Christensen Architects

Intake Screening Comment Responses

Helling Addition
8925 SE 58TH ST,
Permit #: 2301-116

1 SITE PLAN  
SCALE: 1/8" = 1'-0"

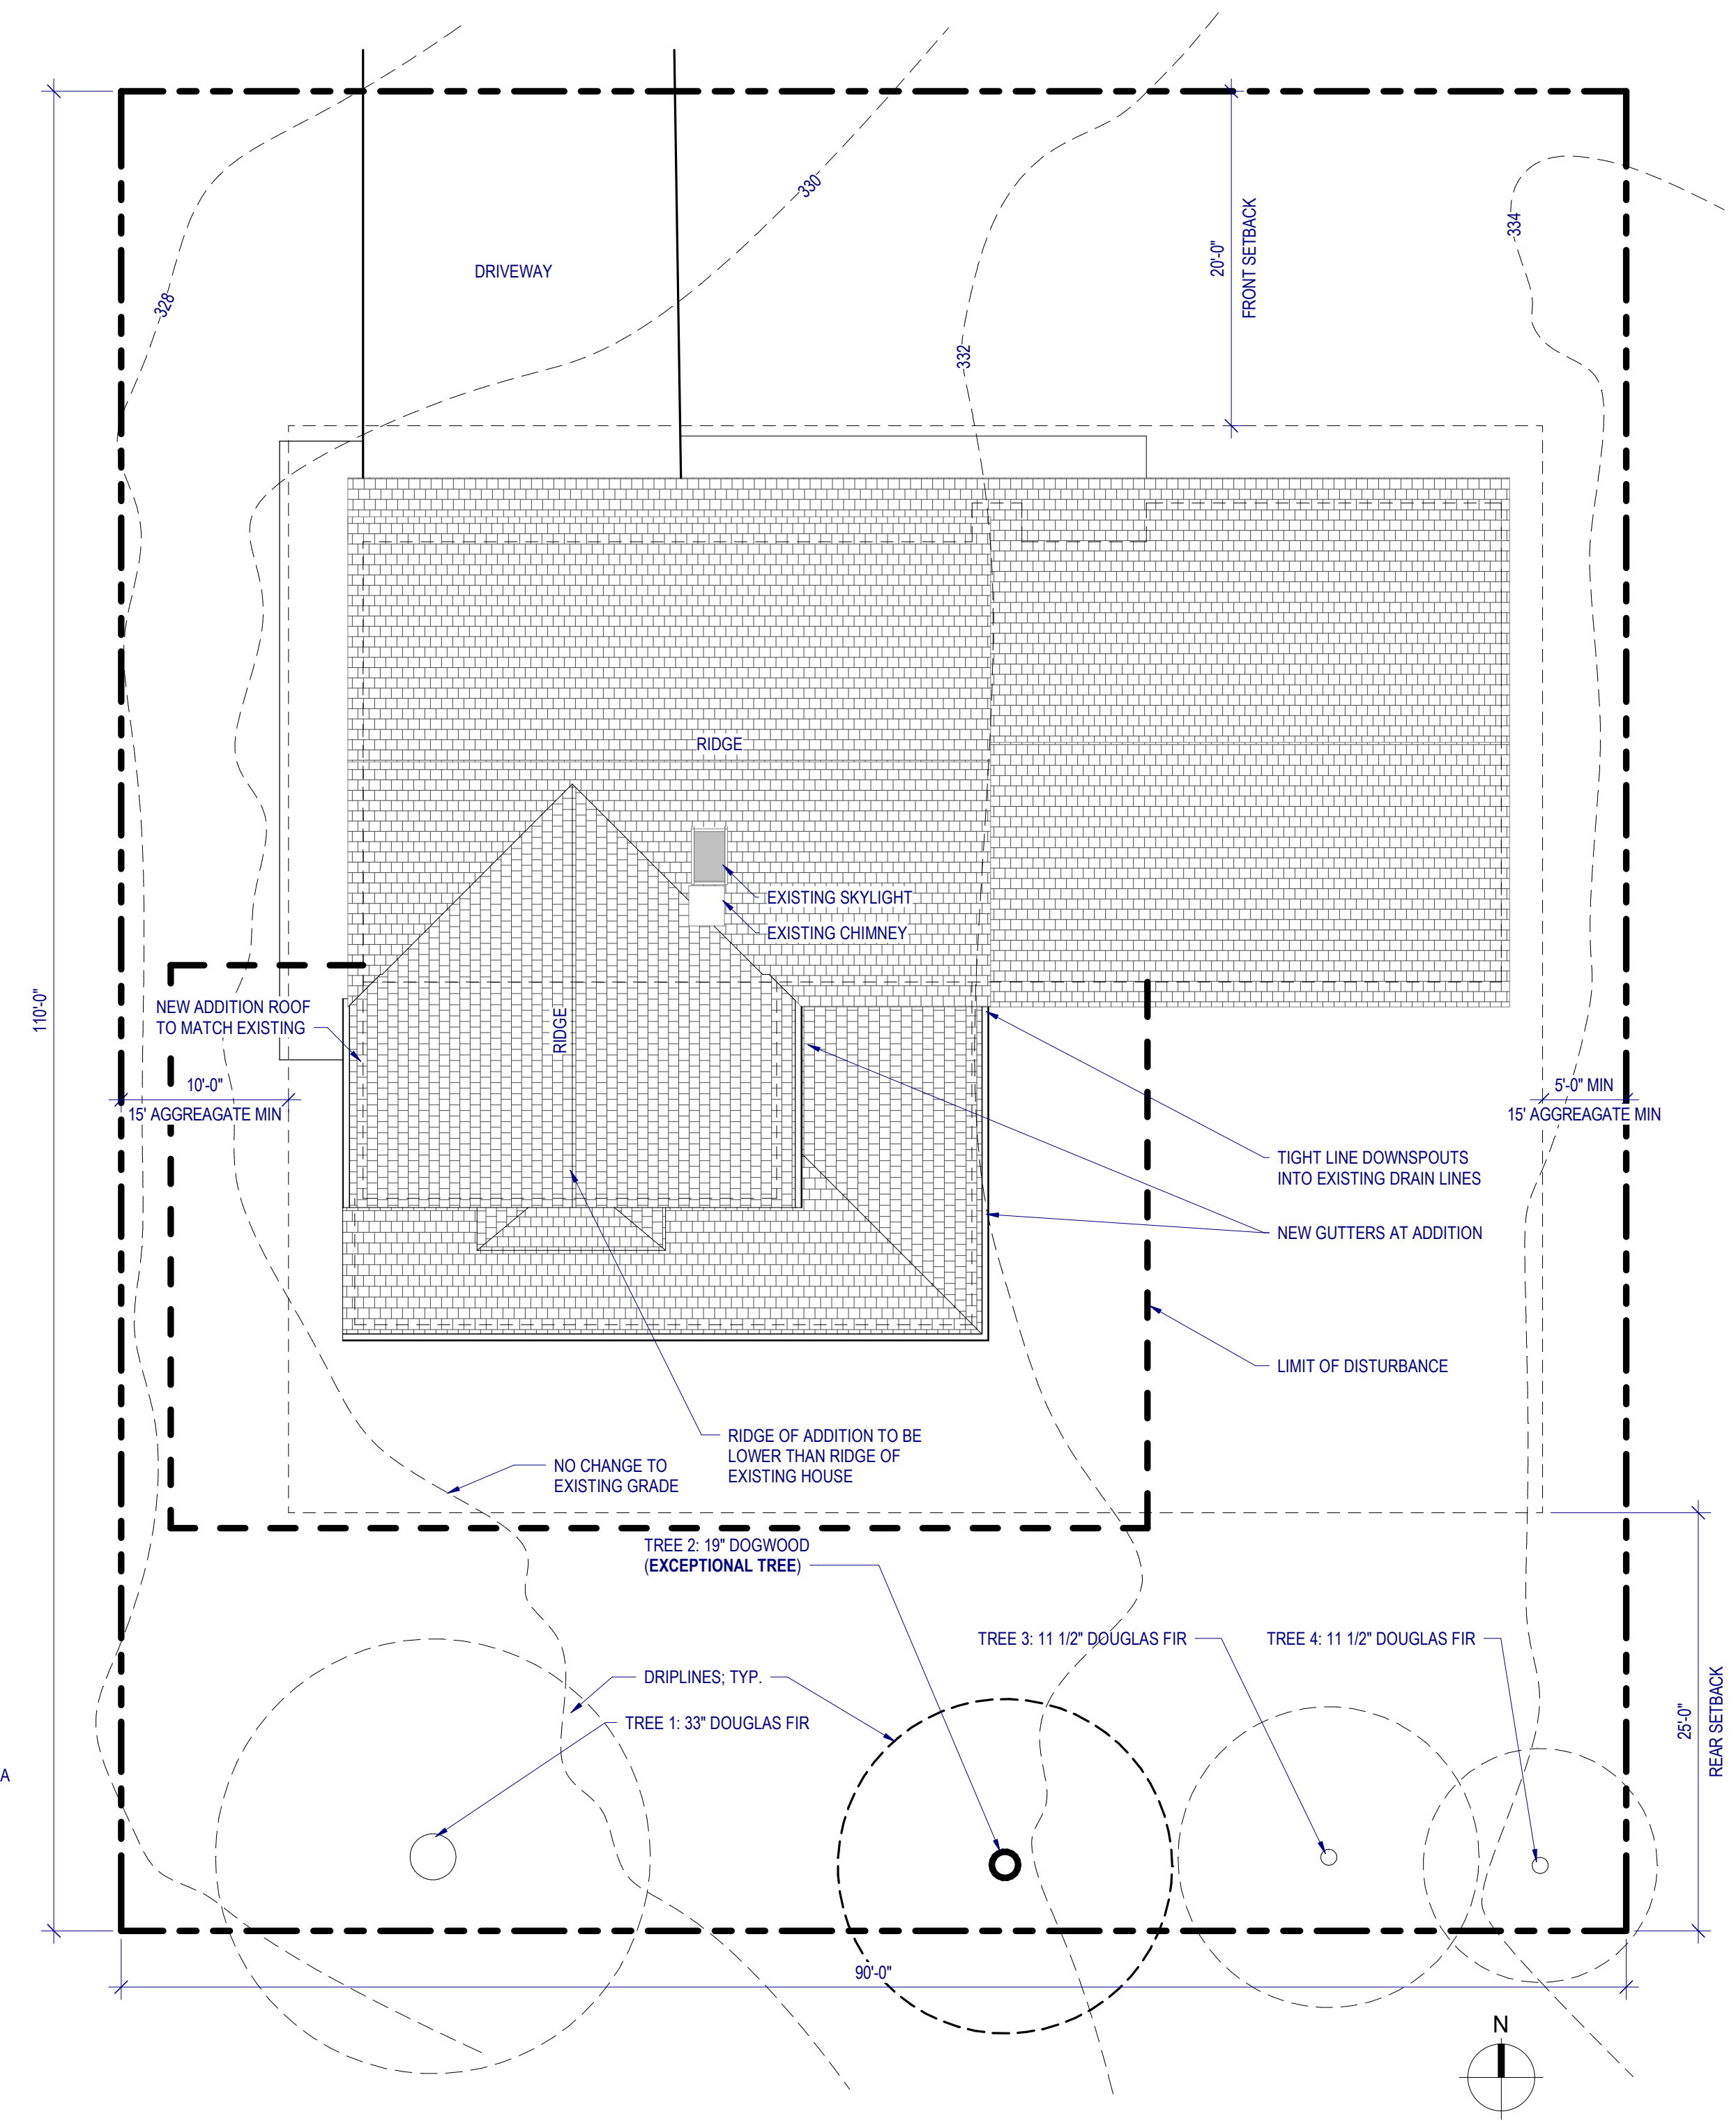
Tree locations, sizes, and species shown on sheet A1.00 Site Plan.
Tree Inventory Worksheet provided.

**1 NORTH ELEVATION**  
SCALE: 1/4" = 1'-0"

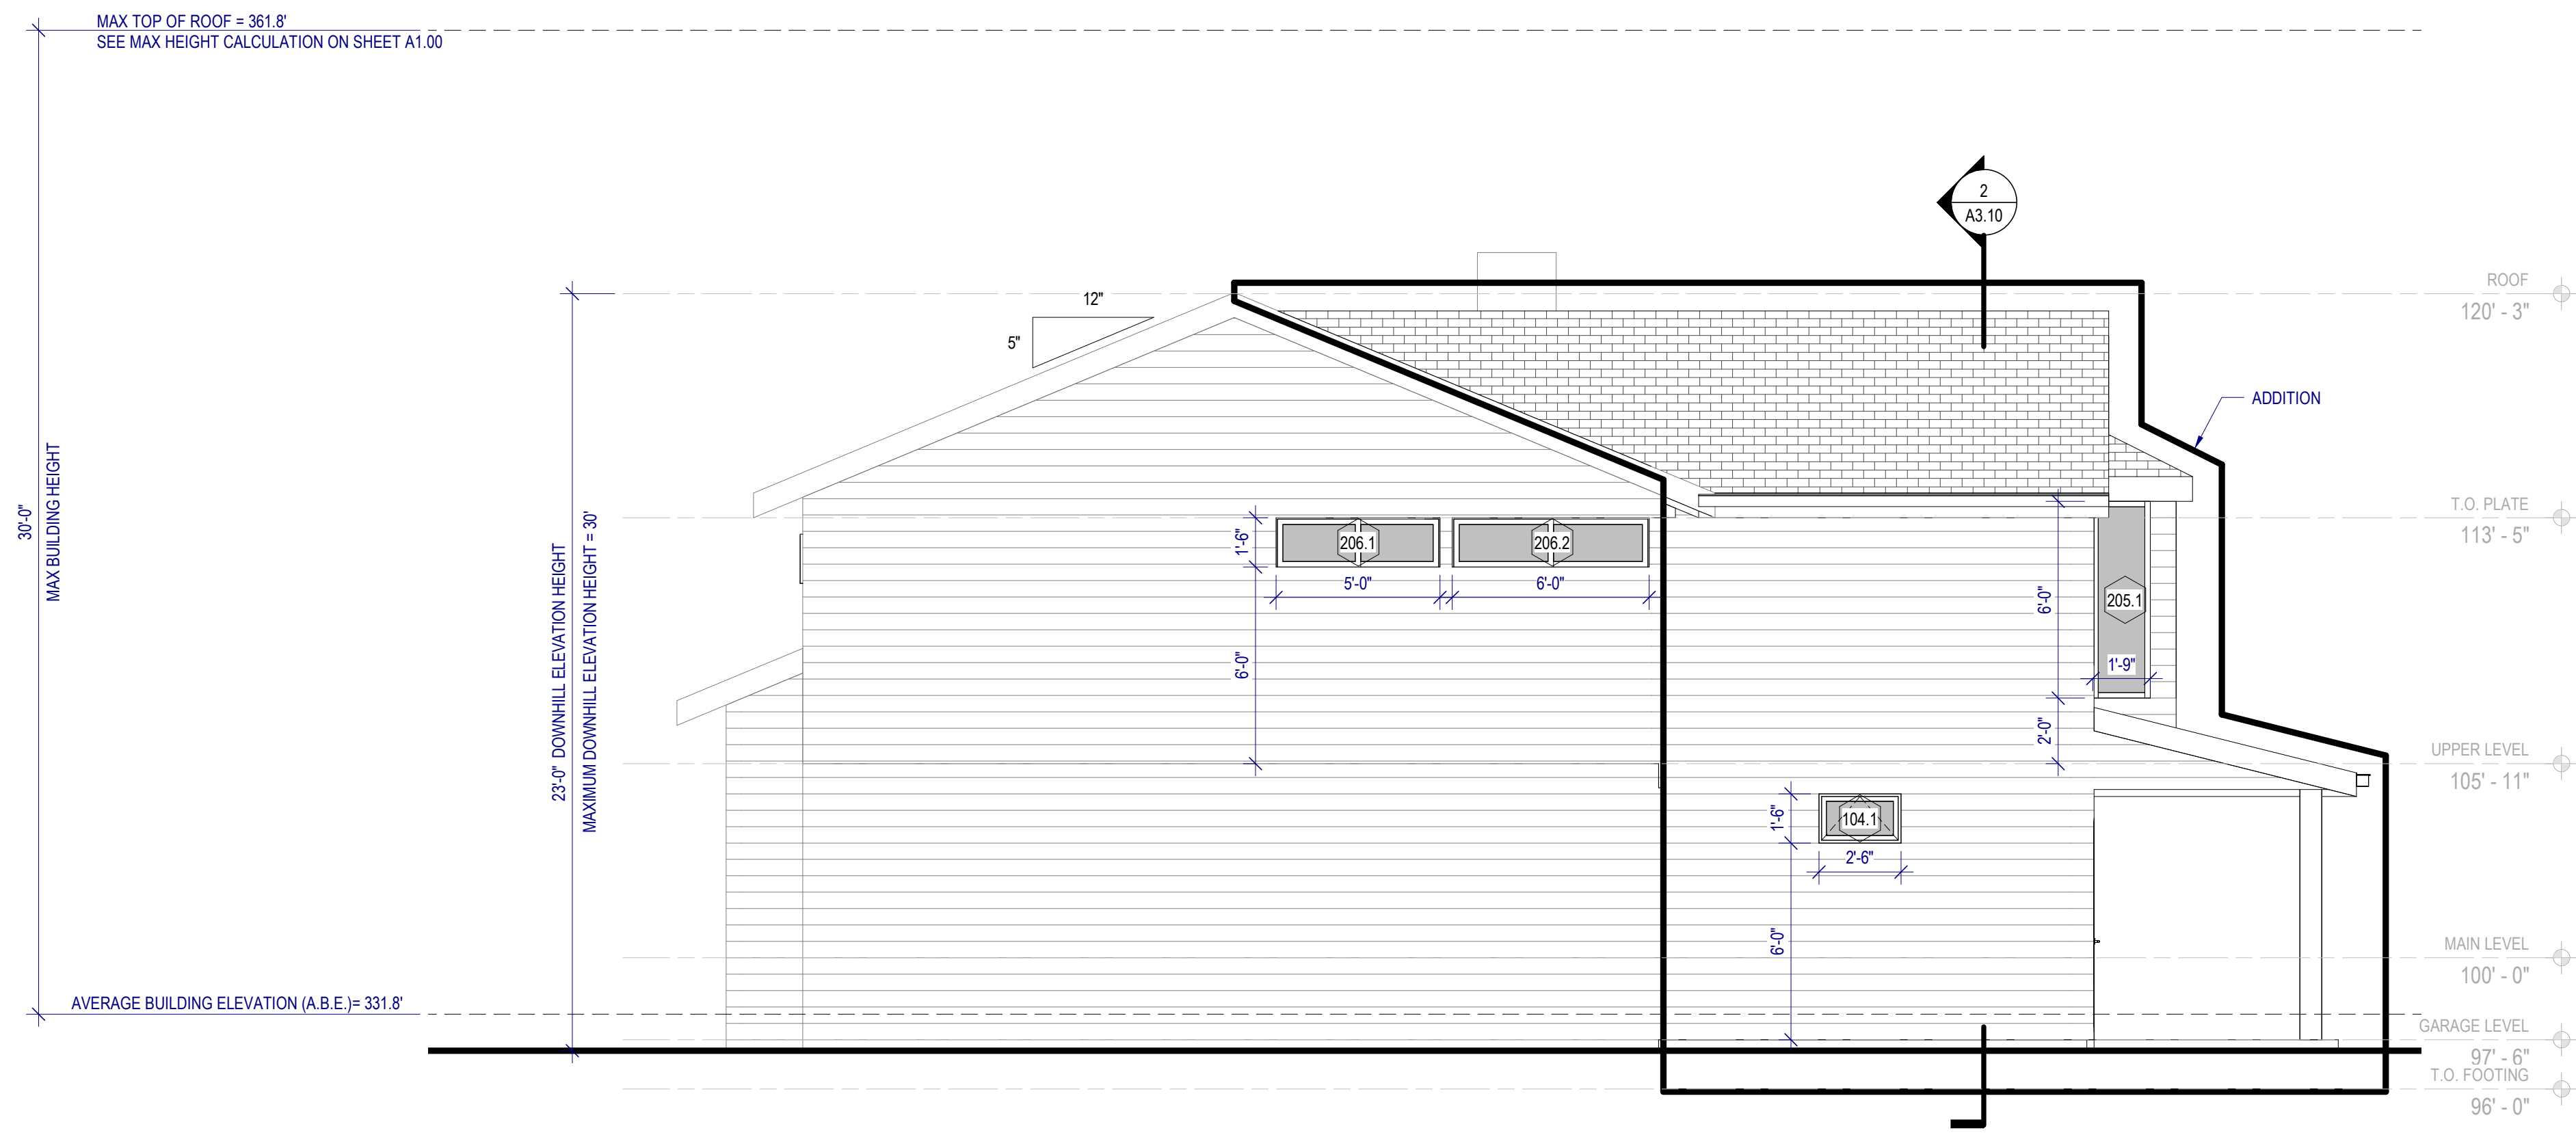
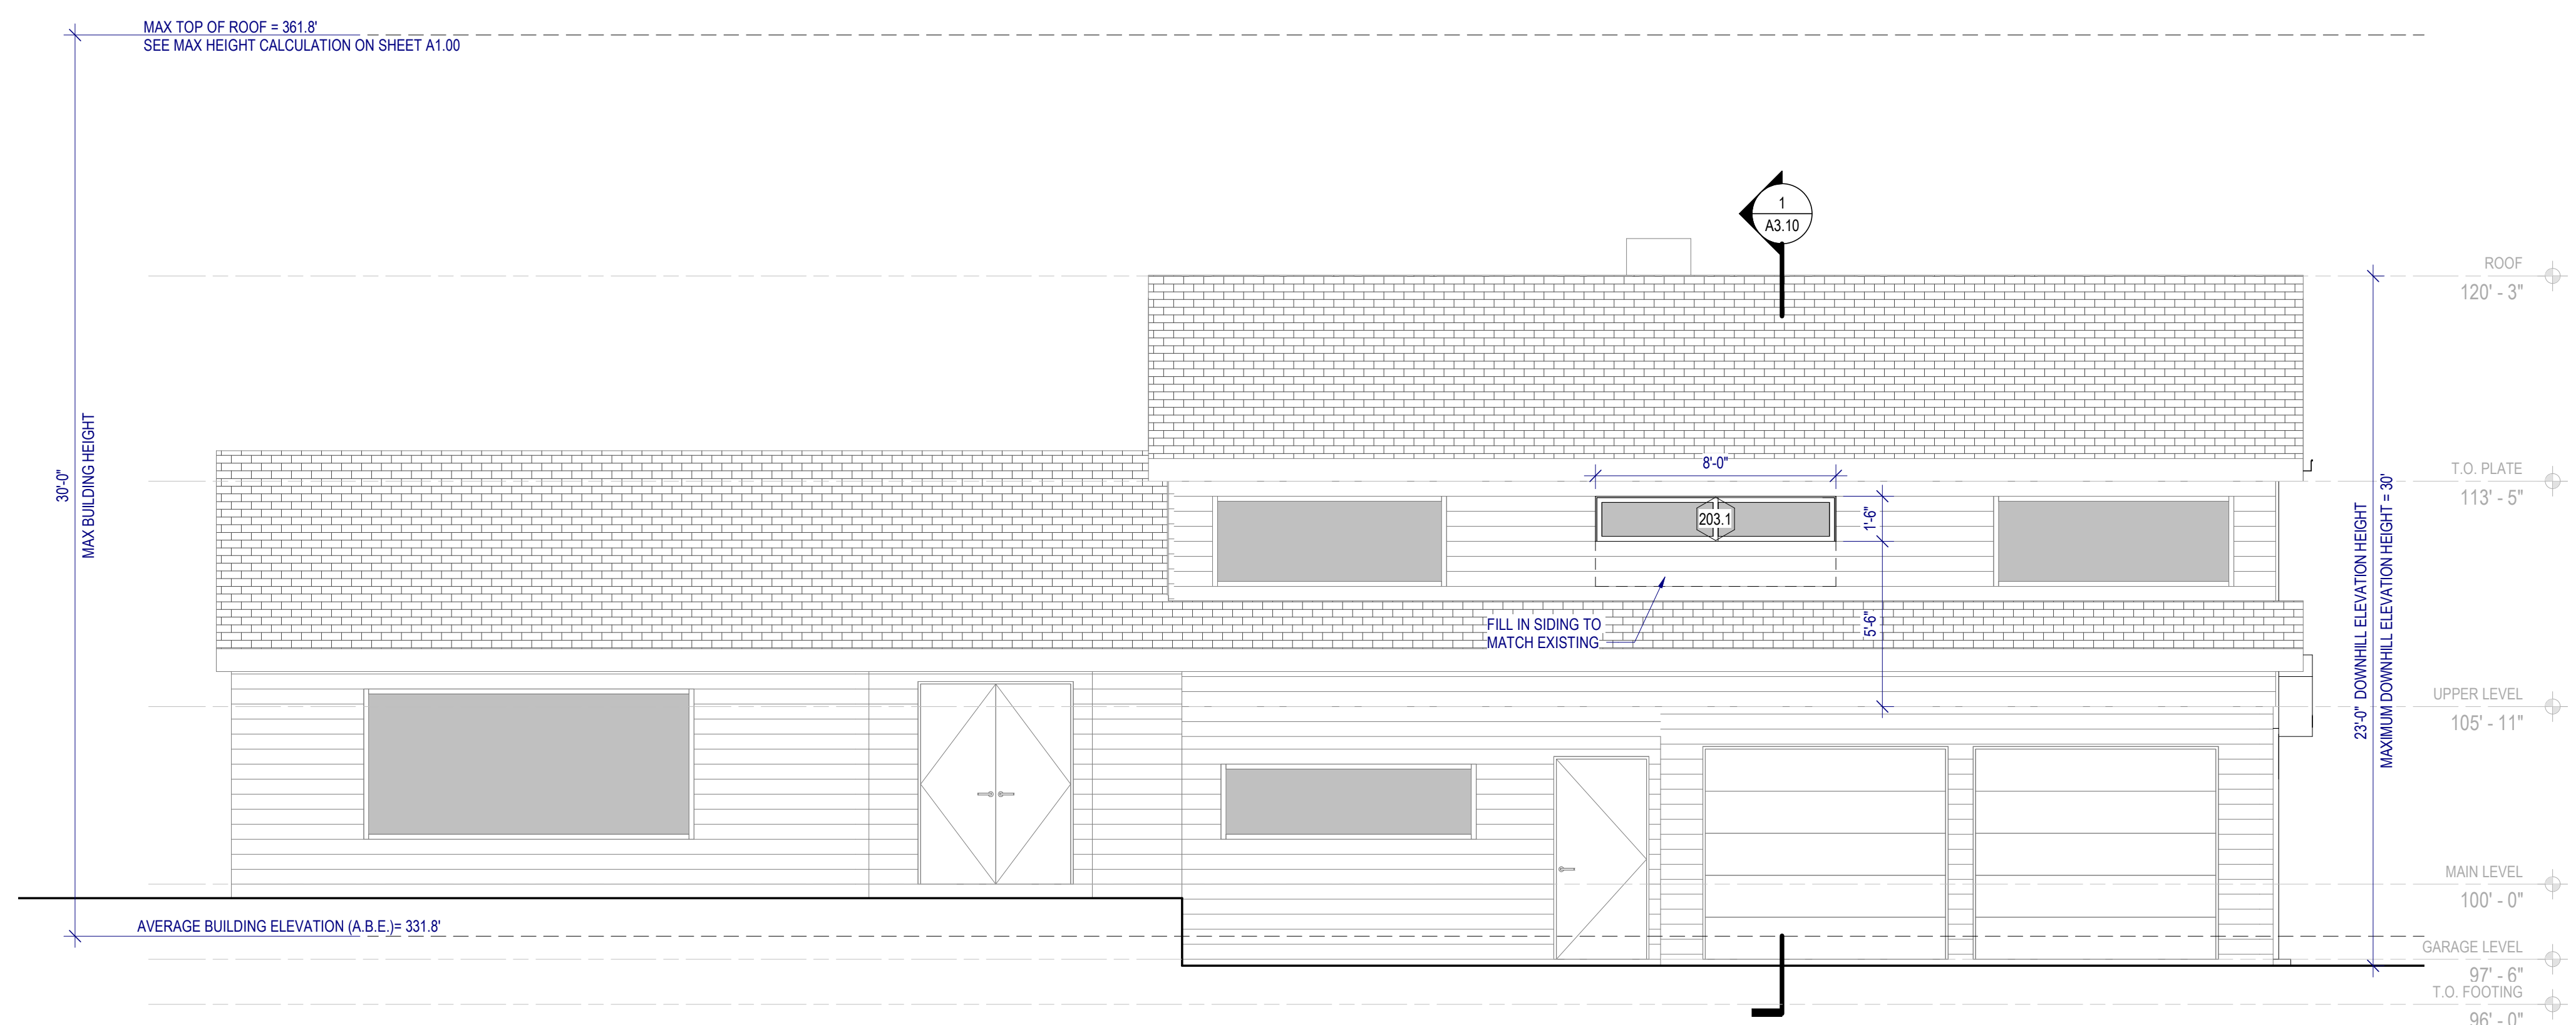
Requested building height and grade notations provided on sheets A3.00 & A3.01.
No proposed changes to existing grades as shown on sheet A1.00 Site Plan.
